Recommendation Report for Planning Permission for Works or Extension to a Dwelling

REF NO: LU/312/14/HH

LOCATION: 13 Irvine Road
Littlehampton

PROPOSAL: Raise height of existing front boundary wall.
This application may be determined under delegated powers by Littlehampton Town Council. This application affects the character and appearance of the Littlehampton Seafront Conservation Area.

DRG No 945-2 A

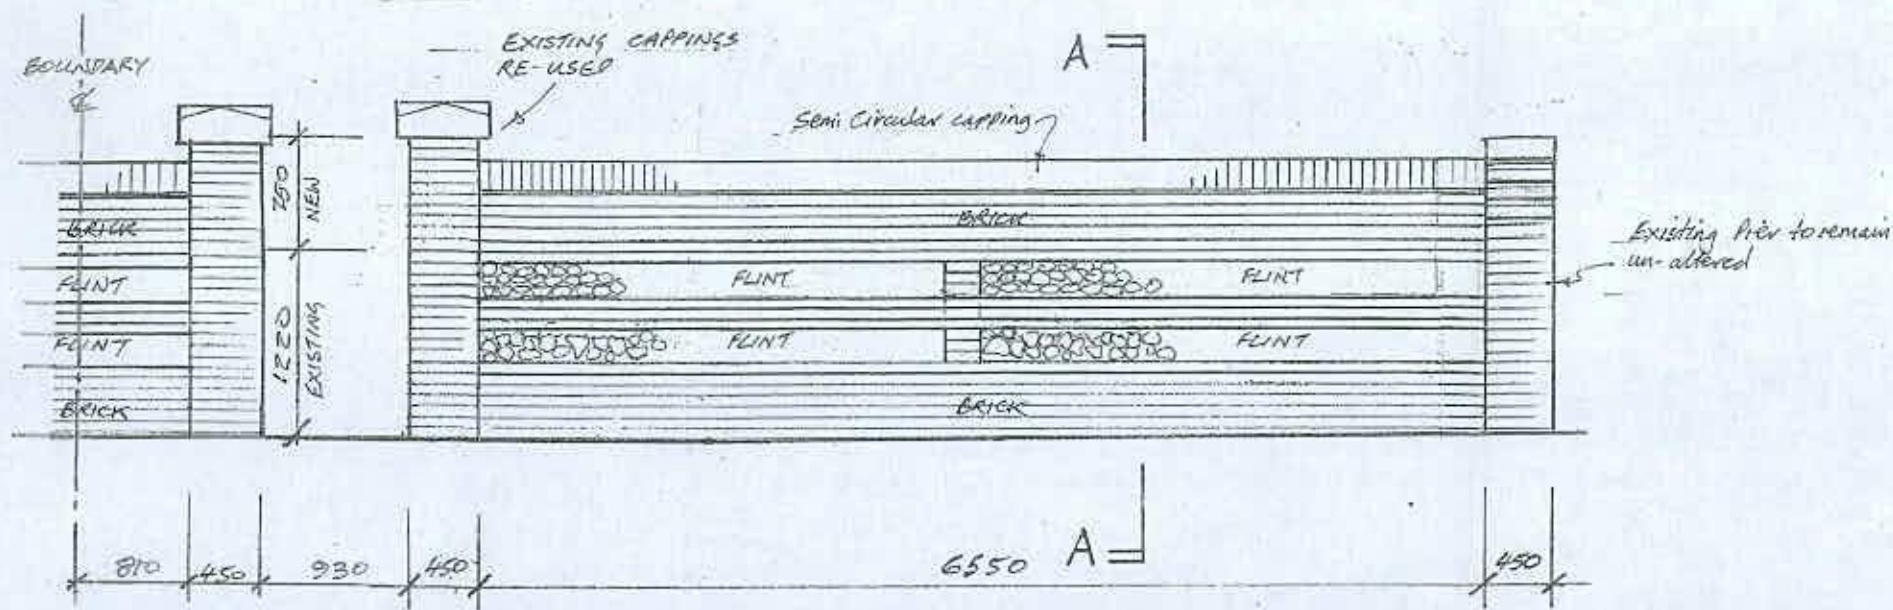
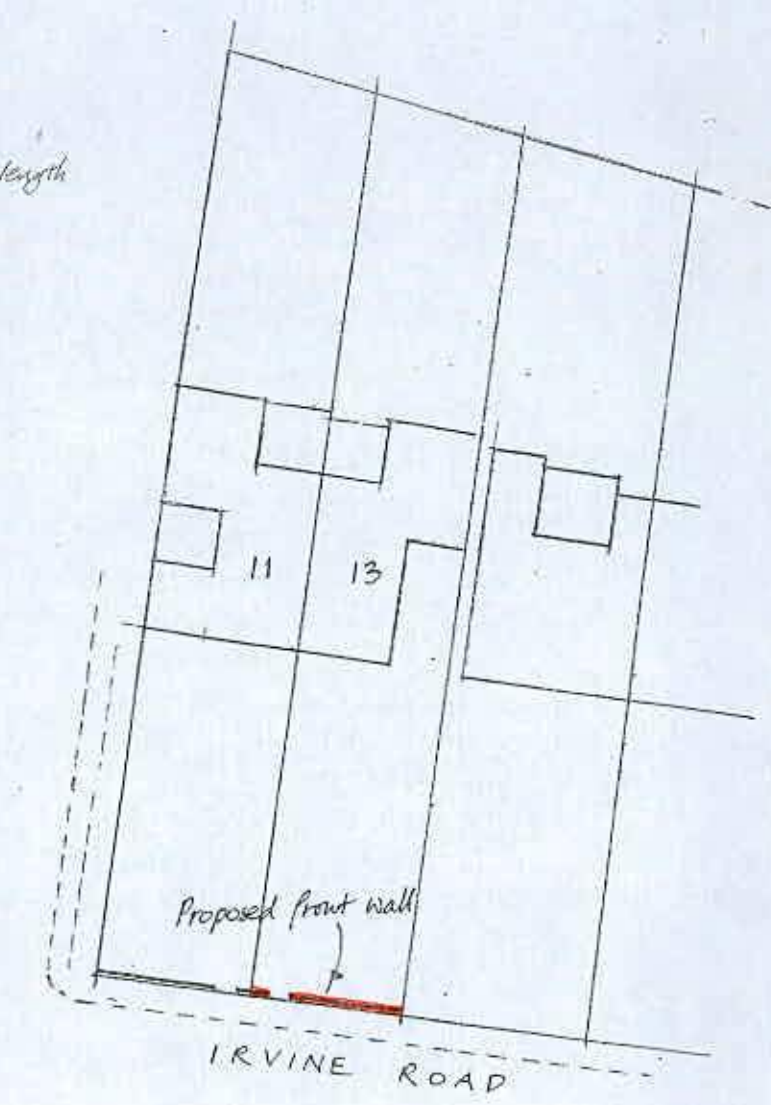
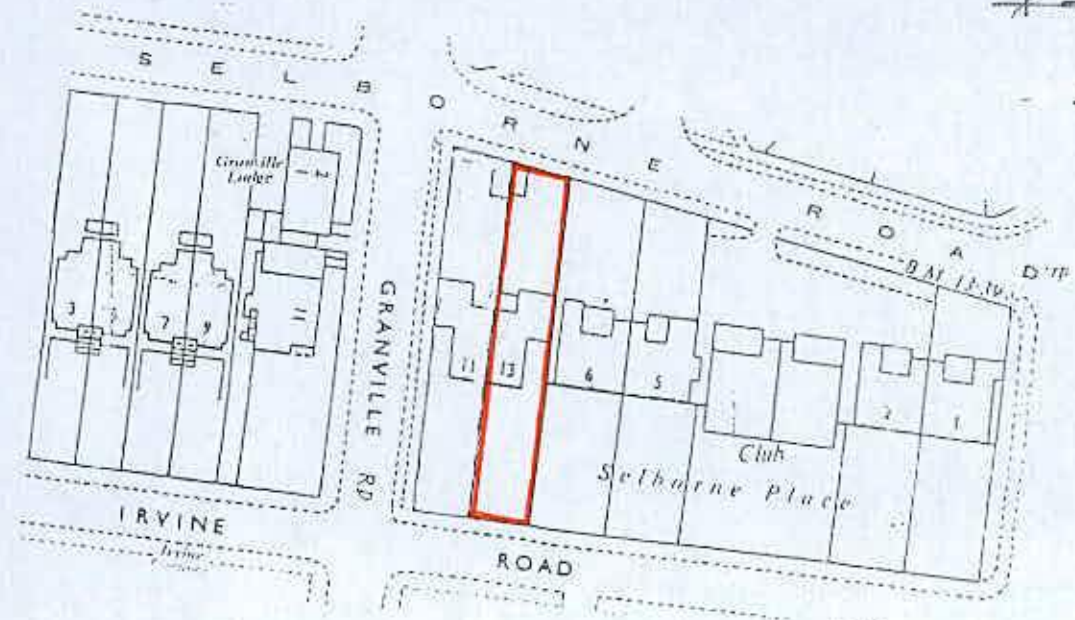
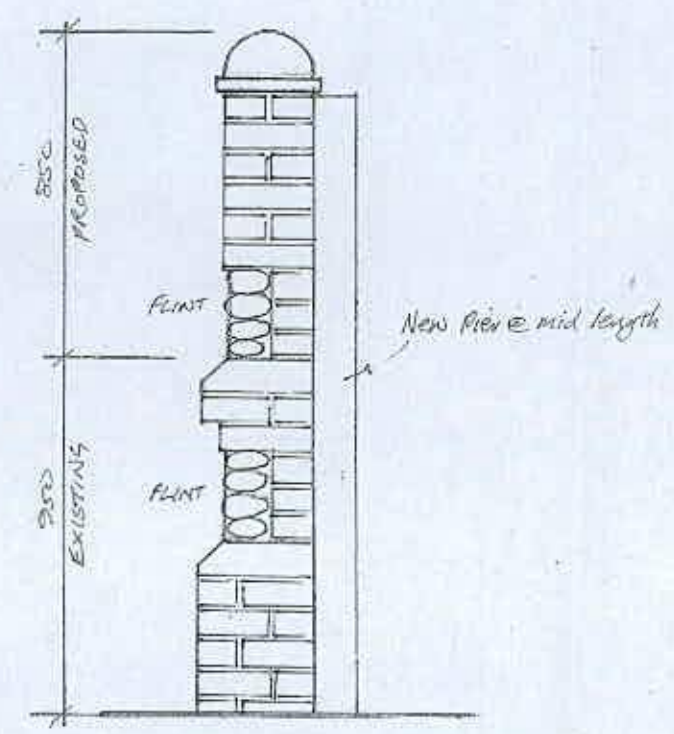
Objection for several reasons - suggested height too heavy for existing wall. Would prefer the wall to be raised as high as the one next door. But unless the entire length of wall was done this does not enhance the conservation area. Perhaps the case officer could explore both properties building their walls together to the same height of the existing wall of the tallest property.

Boundary wall design required to provide adequacy under wind loads for increased height. Existing wall foundation to be exposed and assessed for adequacy to support additional load.

This therefore raises the question of whether the walling can and should be raised. Has the existing wall got the potential to be raised without additional works being undertaken, i.e. demolition and rebuild?

It is considered that raising the wall will affect its appearance and make it more prominent as part of the street-scene. It is noted that the new section of walling appears to terminate abruptly. Any works would have to be undertaken in conjunction with the neighbouring property (number 11) to ensure continuity. It is assumed that this would then encompass the entire boundary of the neighbouring property.

Any works should reflect the general/average height of the remainder of the walling along that entire stretch. The new section of walling would be constructed to a height where it would also be much taller than the neighbour and the relationship with the existing decorative pier would be

It is also noted that the application is not accompanied by structural calculations for the increased height of the wall. Therefore, this information should be provided to confirm that the wall would be structurally sound under wind loads given its increase height.

- 1 The proposed increase in height of the existing front boundary wall fronting Irvine Road will have an unacceptable prejudicial impact on the character and appearance of the area and will not preserve or enhance the character and appearance of the Conservation Area

- 2 Based on the submitted information the Local Planning Authority is not satisfied that the structural integrity of the wall is adequate and the proposal therefore conflicts with policy GEN7 of Arun District Local Plan.
